DEPARTMENT OF THE ARMY
WILMINGTON DISTRICT, CORPS OF ENGINEERS
151 PATTON AVENUE
ROOM 208
ASHEVILLE, NORTH CAROLINA 28801-5006

Action ID No. 200530150, US 64 relocation from US 19/74/129 in Murphy to east of NC 141.
Cherokee County, North Carolina, TIP No. R-0977A

Subject: Correction to 401 Water Quality Certification for R-0977A, DWQ Project No. 20041594V.4
Water Quality Certification No. 3487

TRI-COUNTY COMMUNITY COLLEGE MOD. - MARCH 2008 SITE 16B
 DB 409 PG 75
 DB 363 PG 27
 DB 310 PG 81
 DB 306 PG 121

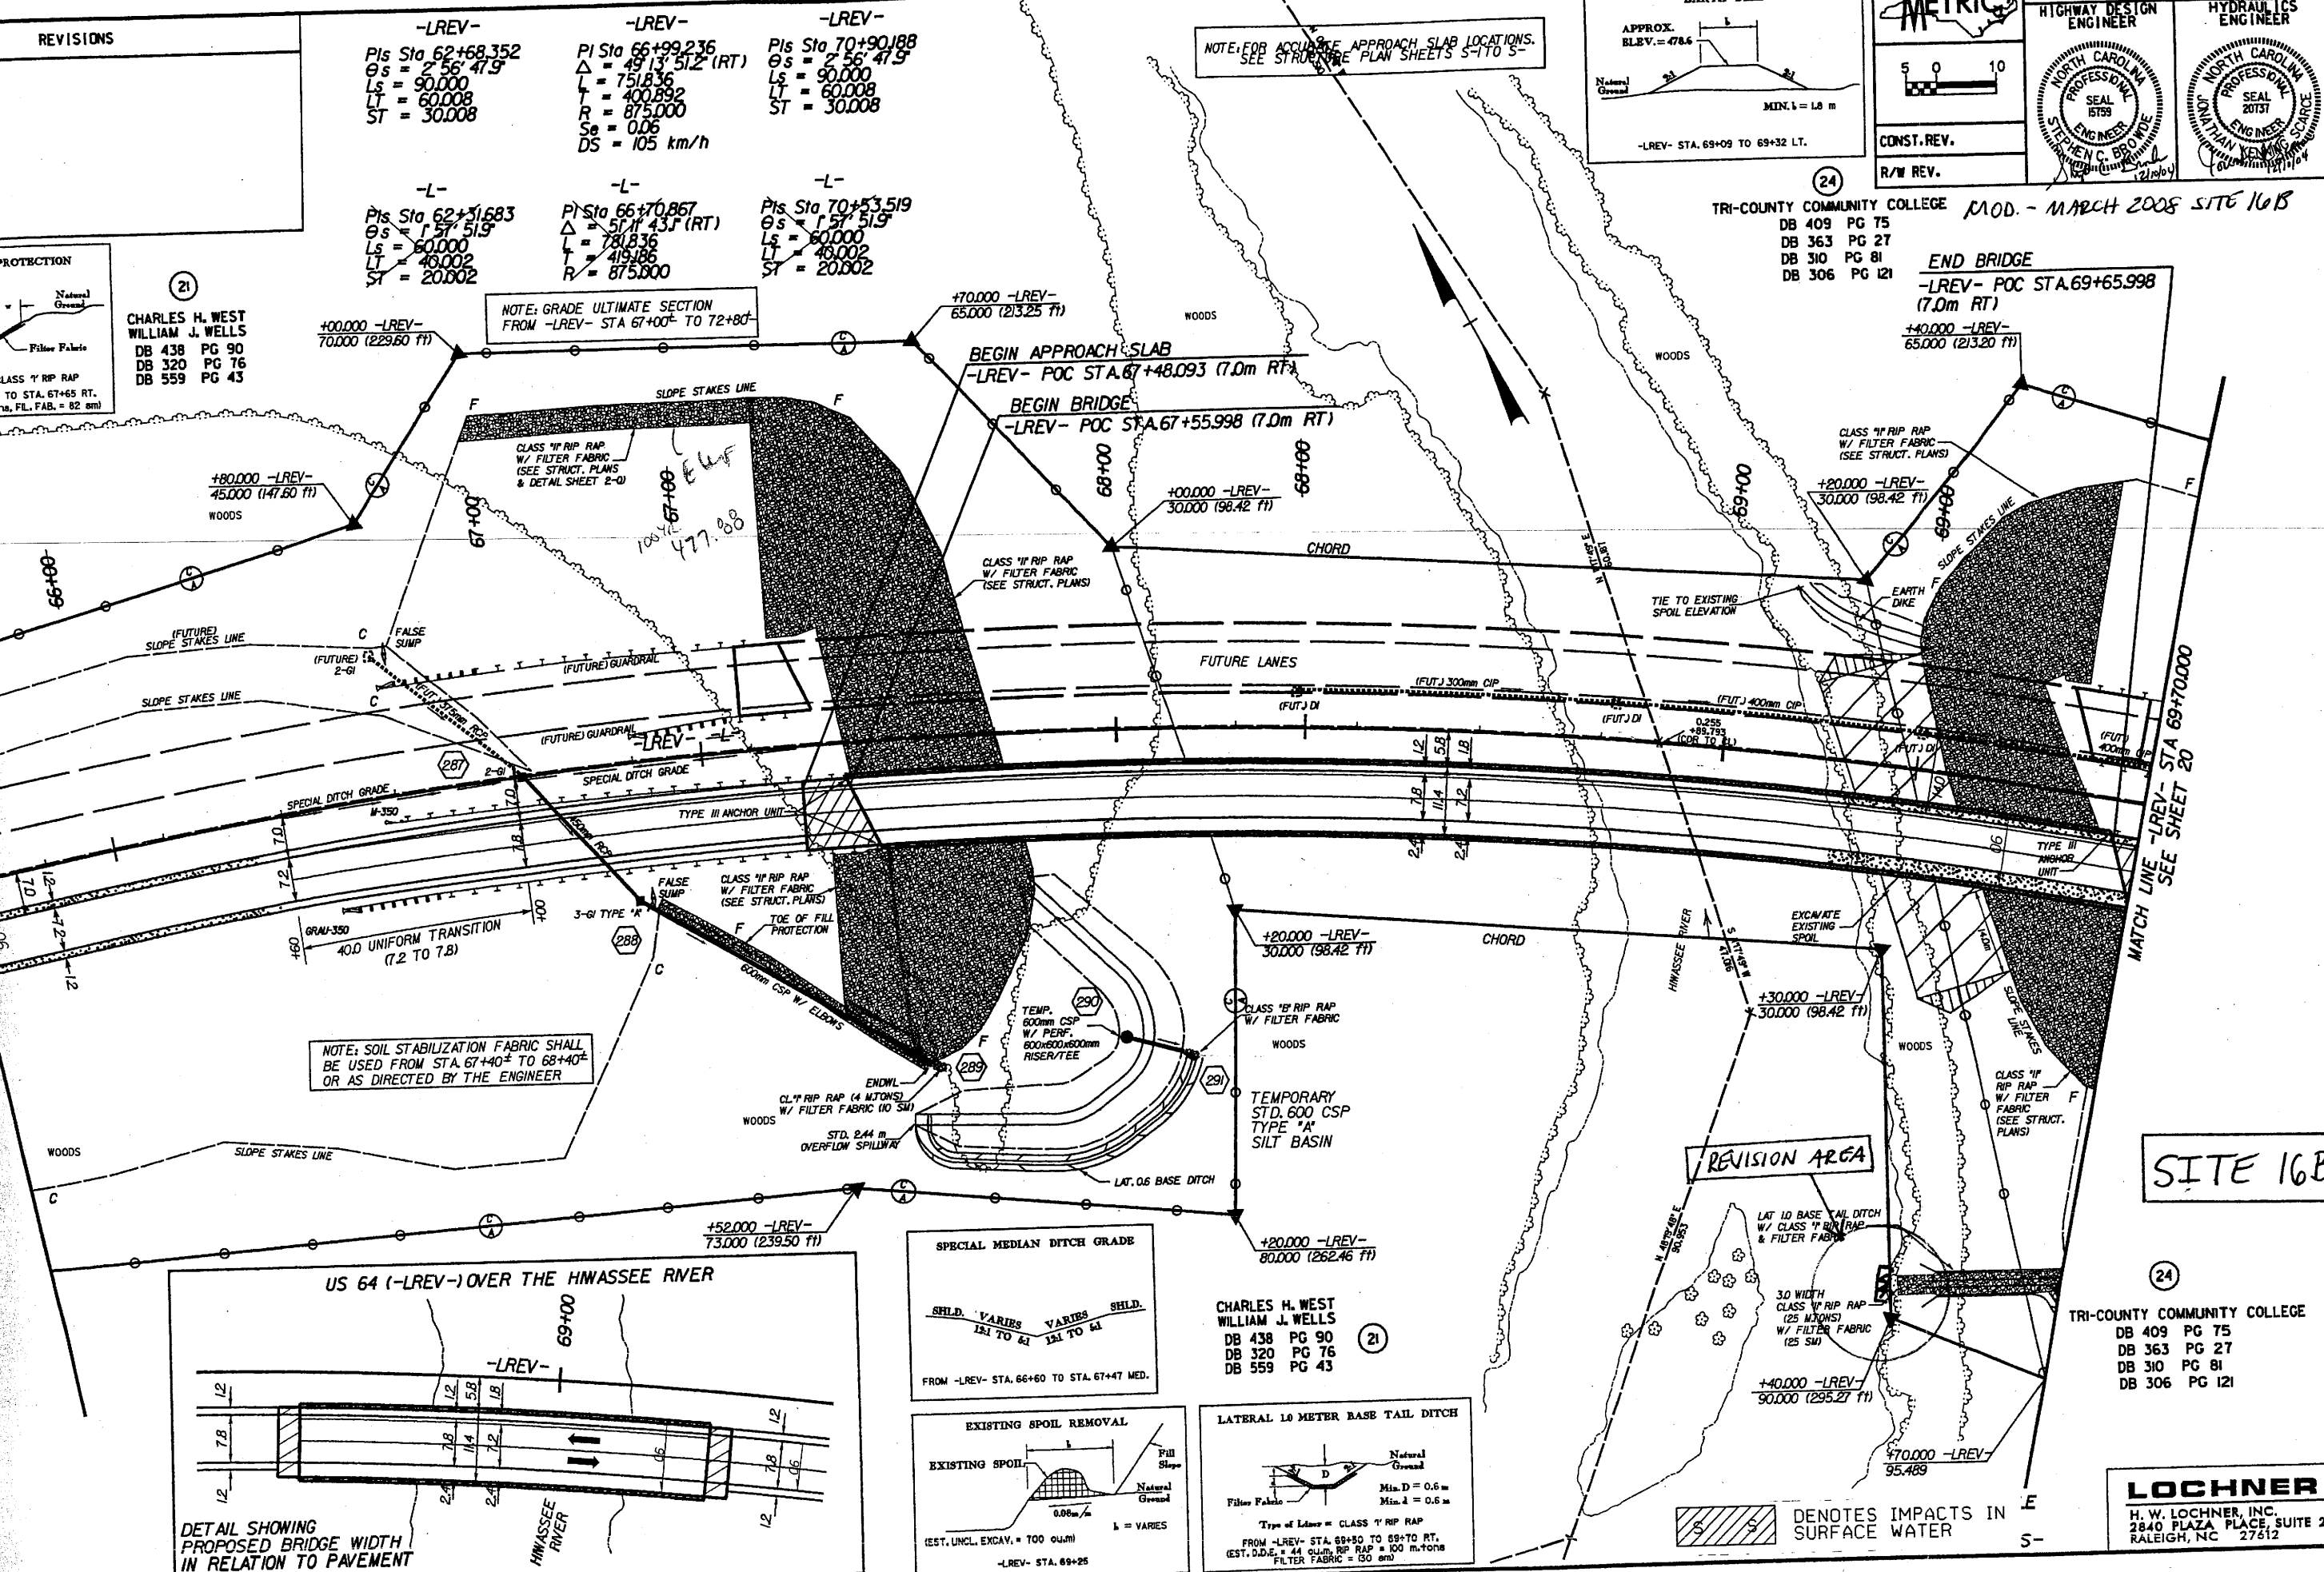
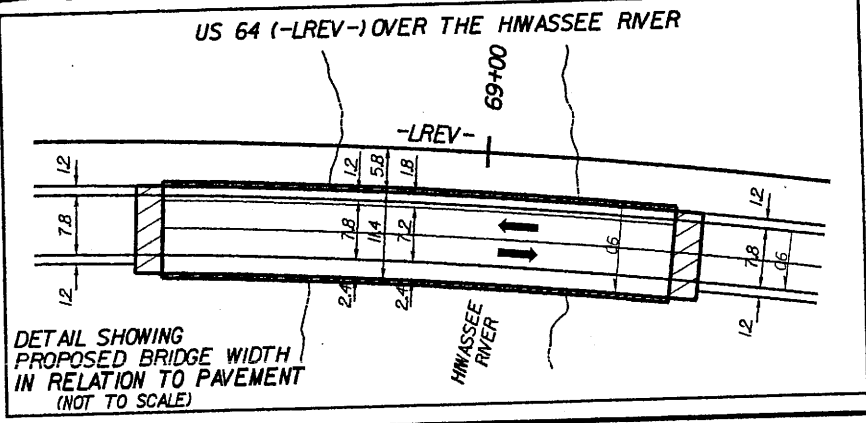
- Site 16B, Hiwassee River streambank. Twenty feet of streambank stabilization to prevent erosion and scour problems at the end of a tail ditch.
- Site 19, Redesign of the Y-line due to residential driveway conflicts. The removal of a 115-foot section of culvert from an unnamed tributary to McCombs Branch and restoration of the channel. The relocation will require the piping of a 92-foot segment and a 28-foot segment of an unnamed tributary to McCombs Branch, as well as the discharge of fill in 0.02 acre of adjacent wetlands.
